**Planning and Urban Development Department
Planning Division**

RE: Comments for Proposed Development – Level III Review

Project:	Building Conversion	Project ID:	2018-011
Project Address:	415 Cumberland Ave.	CBL:	36-G-33
Applicant:	Sam Reiche		
Planner:	Christian Roadman

**A1.01**

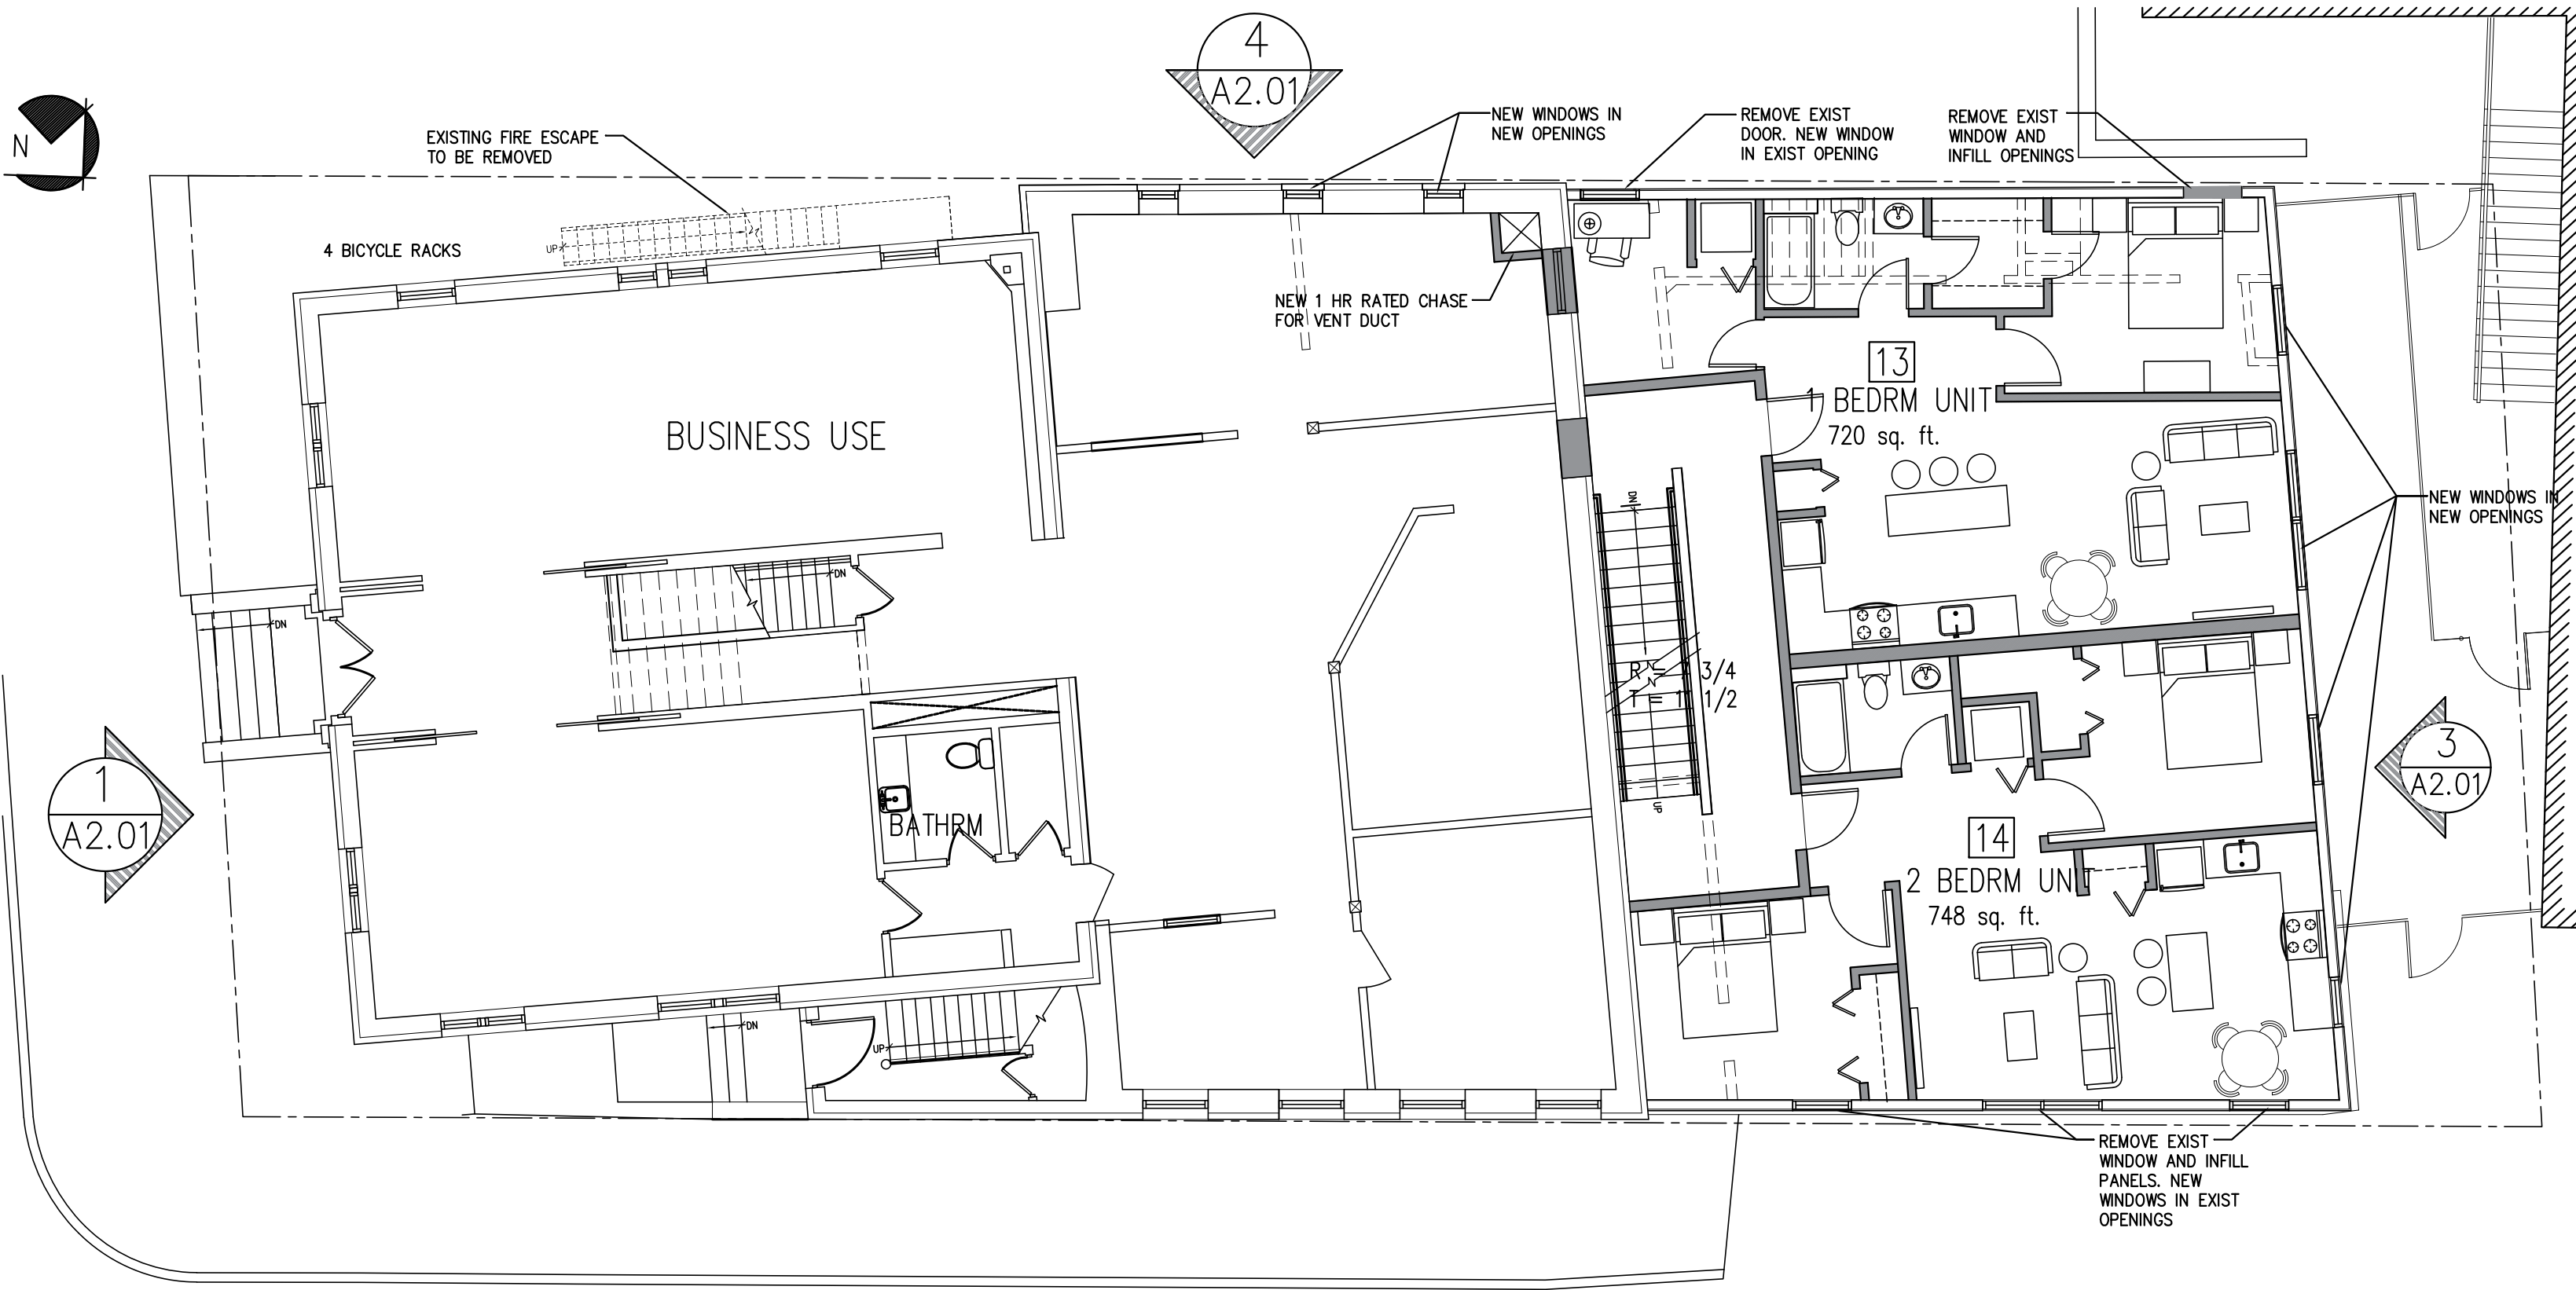
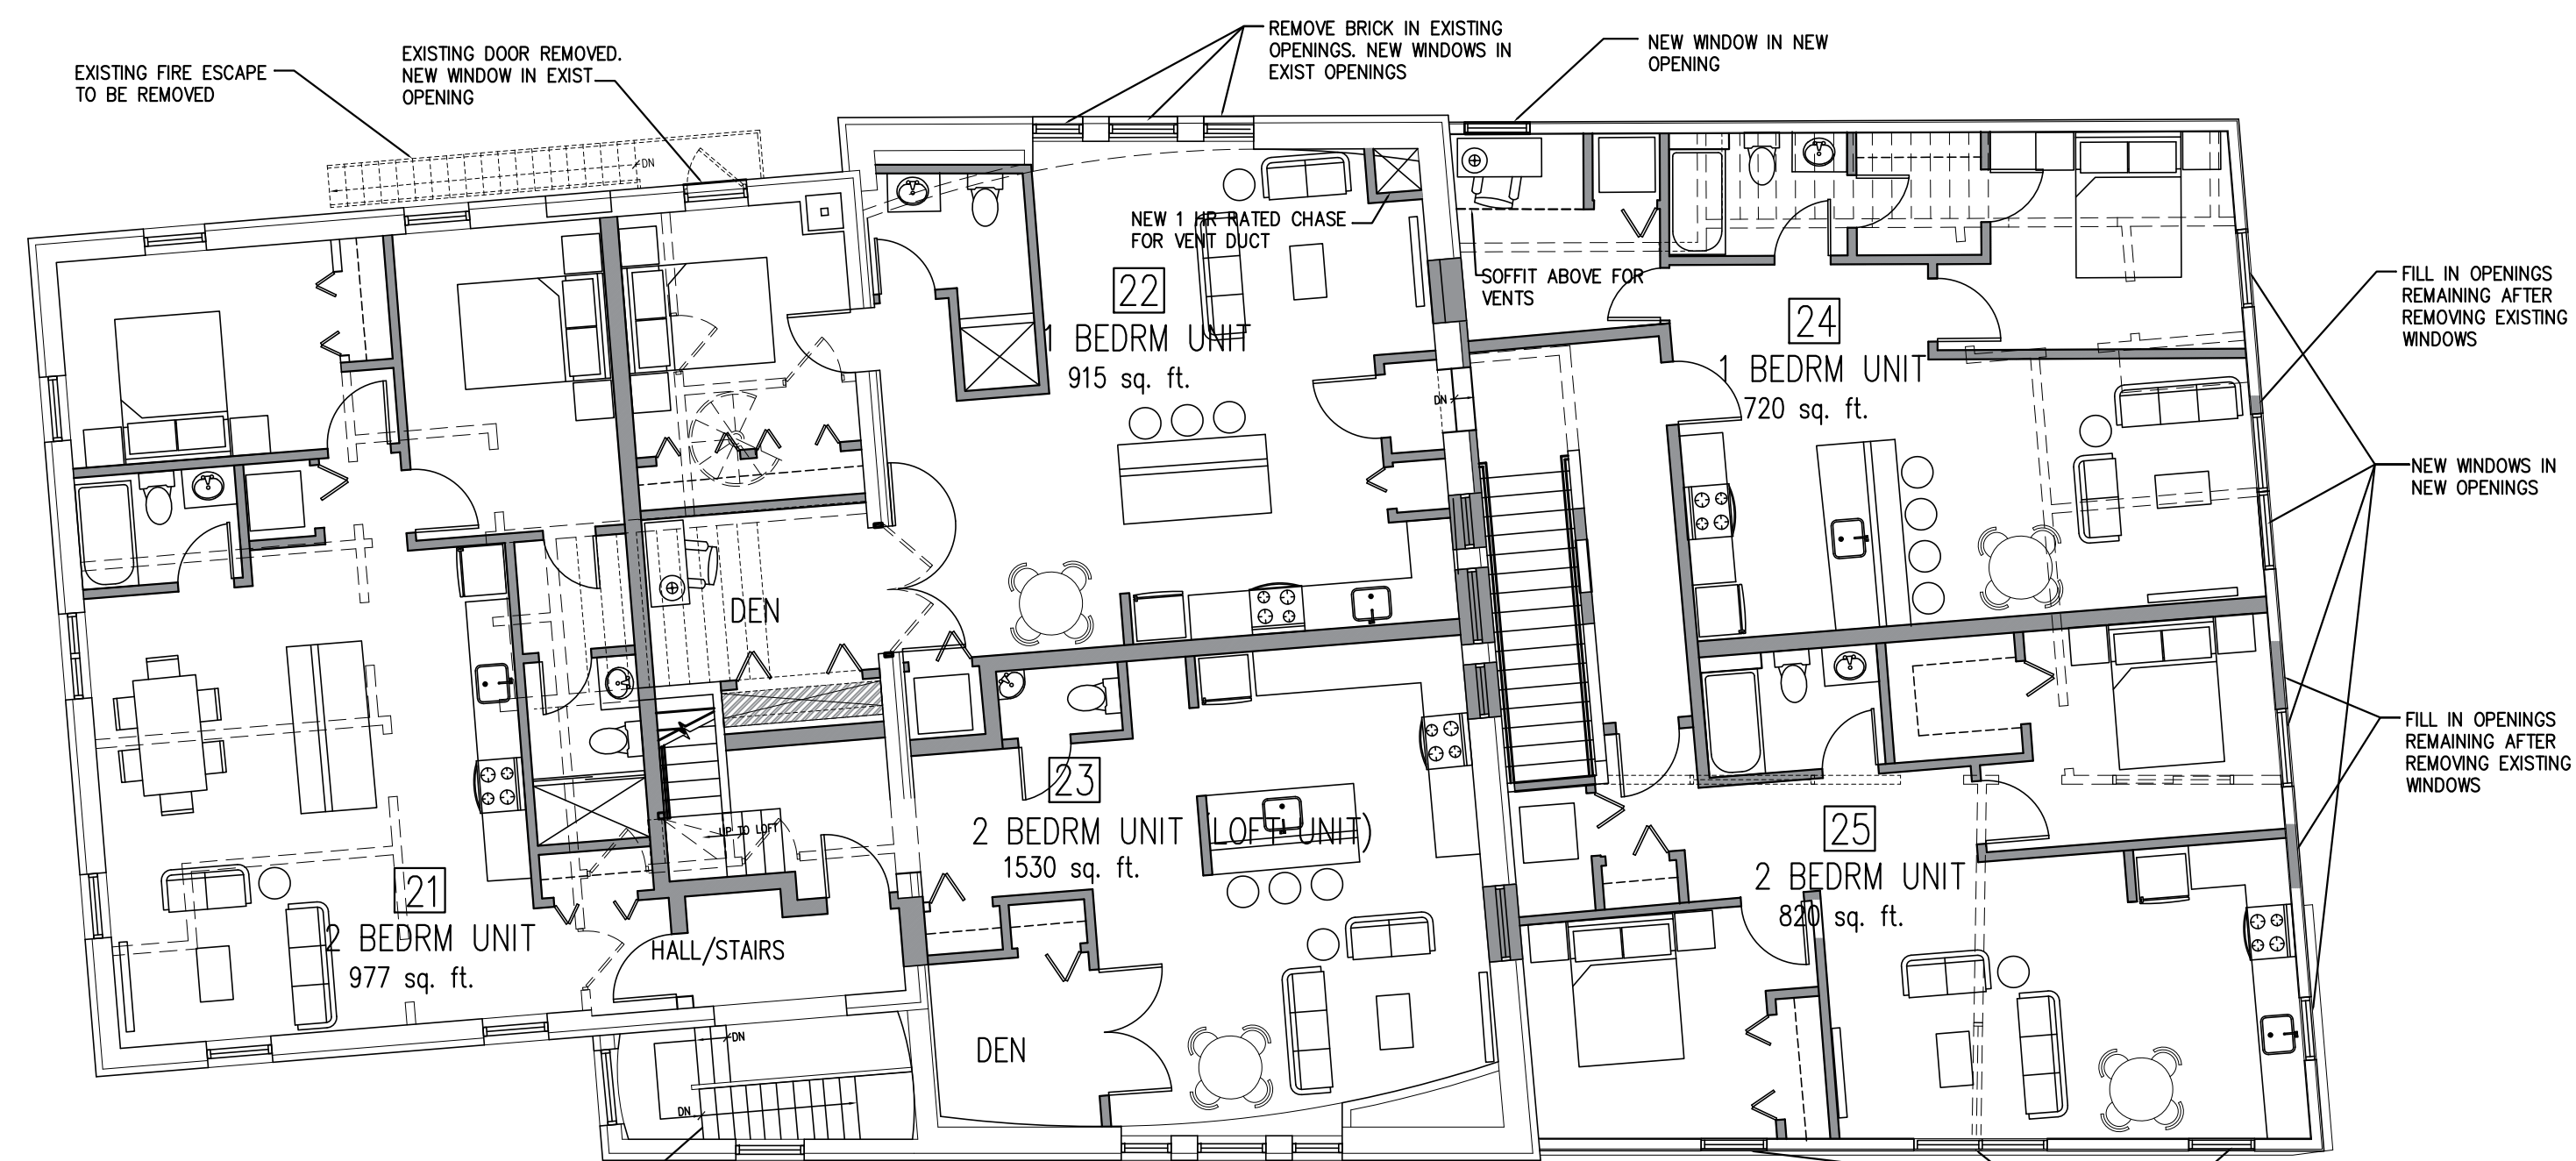
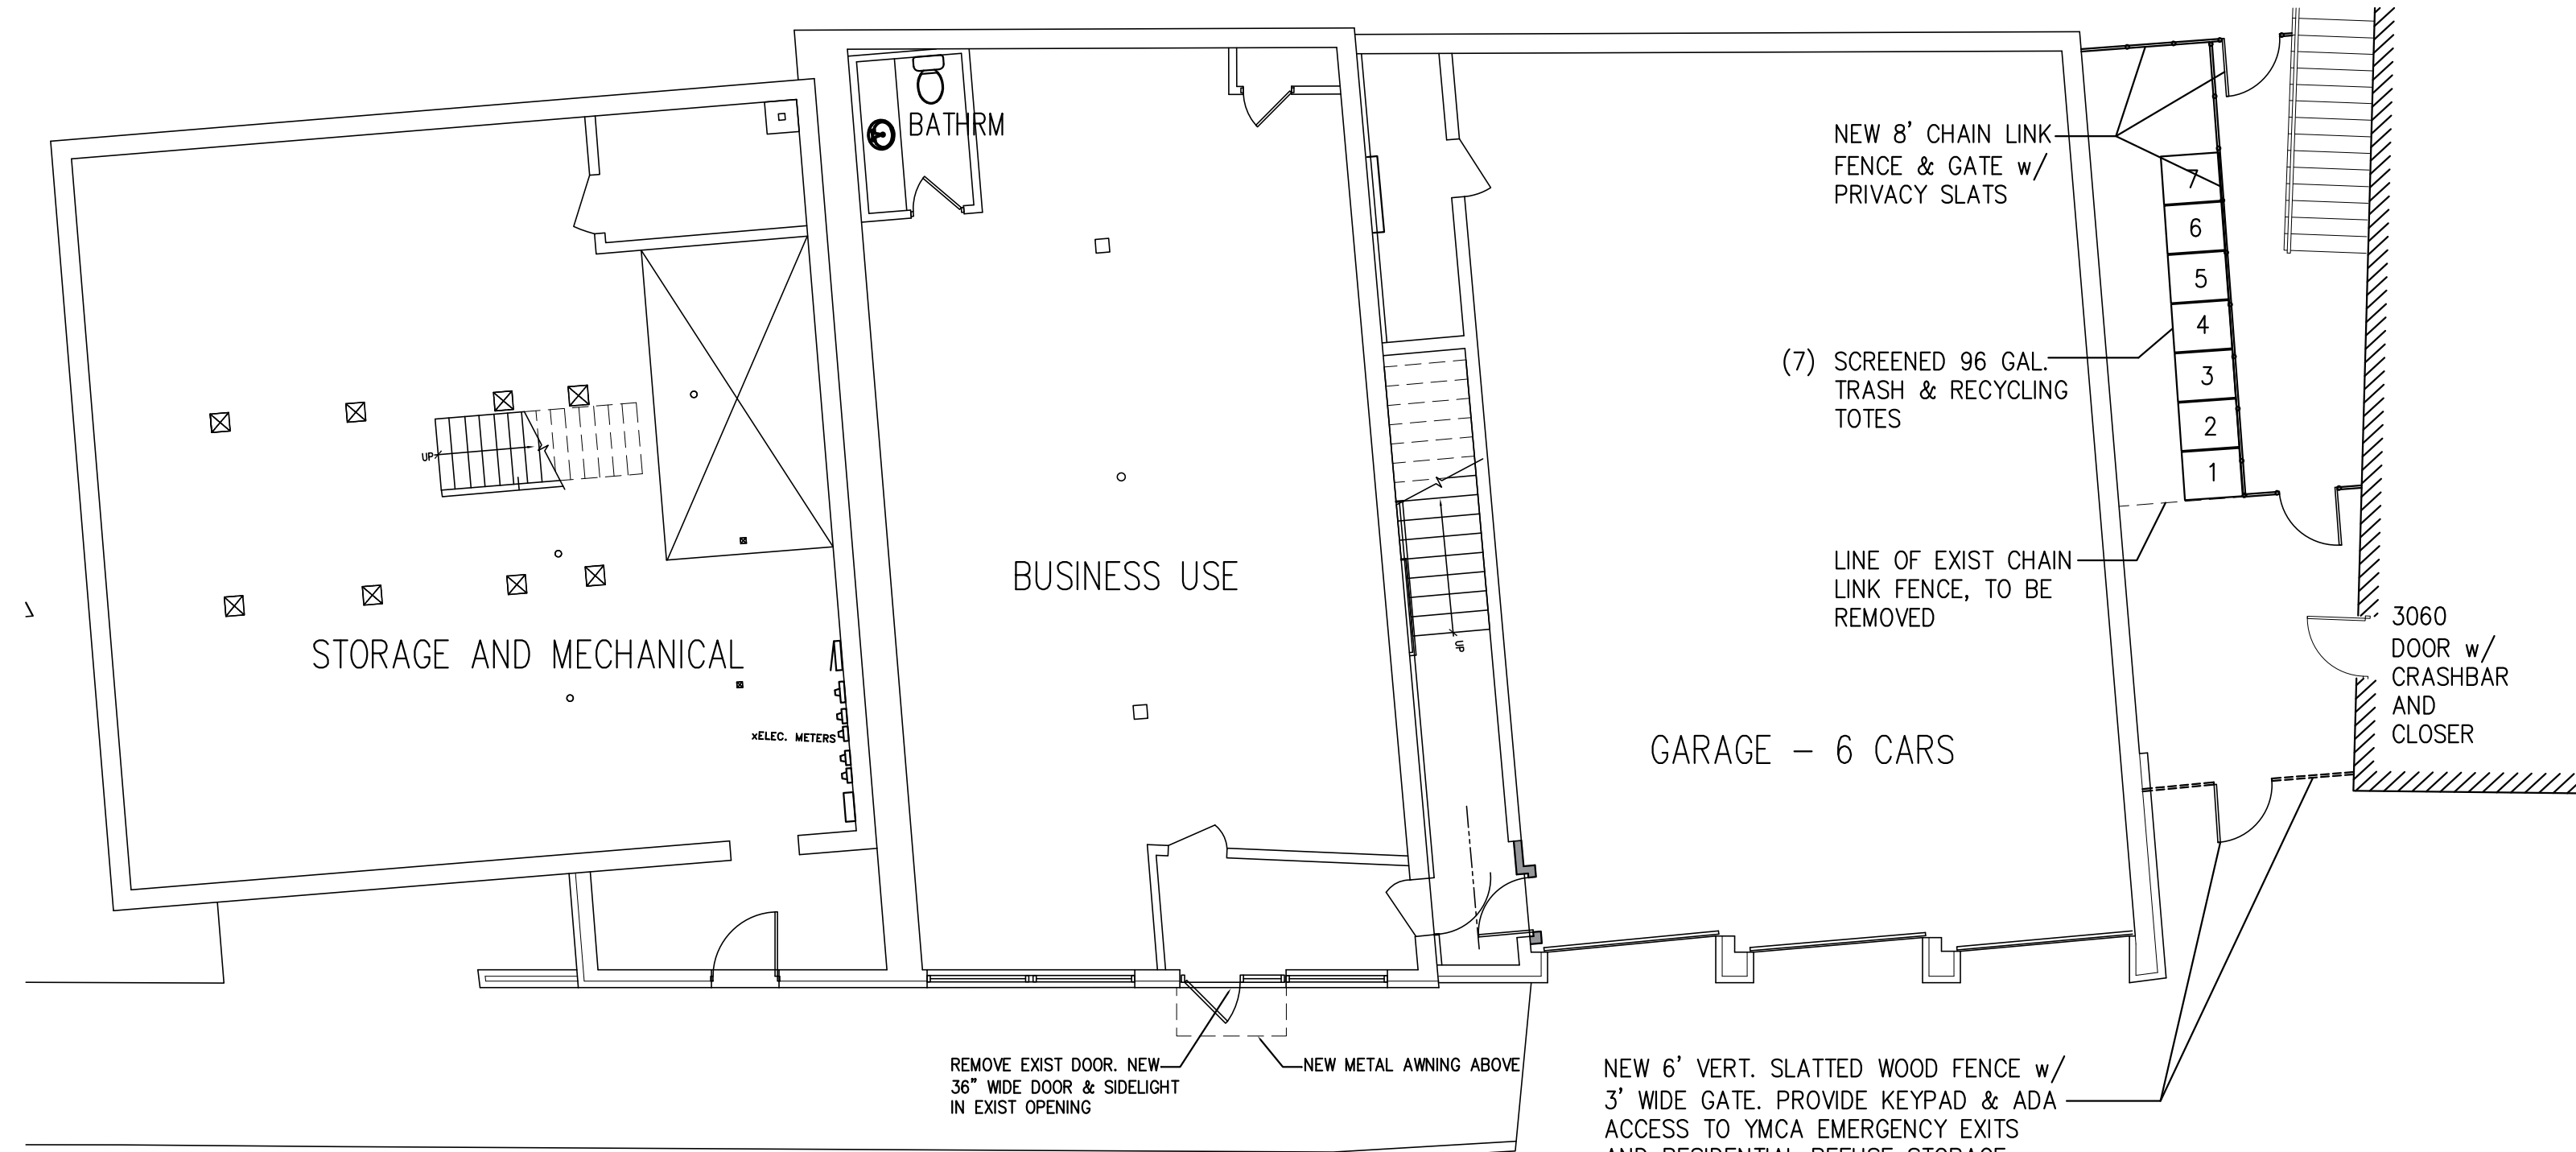
3. Please clarify the number of units proposed for your project, as well as the rooftop access available to any unit. Will the top unit be part of / connected to a unit below? Please also clarify the design of any guardrails / fencing on the roof, and also clarify any roof access from the rooftop unit. I understand that the applicant team has been in contact with permitting / inspections reviewers regarding these items. Please keep planning staff apprised of such life safety-related discussions and any proposed changes they prompt (also see comment 25 below).

7. Please provide floor plans of the existing building, and clarify the existing number of units / commercial spaces. This may impact parking analysis.

14. Please provide more clarity / detail regarding the penthouse / mezzanine. What changes are being made, if any, and what materials are being used? Are the proportions of the existing windows changing?
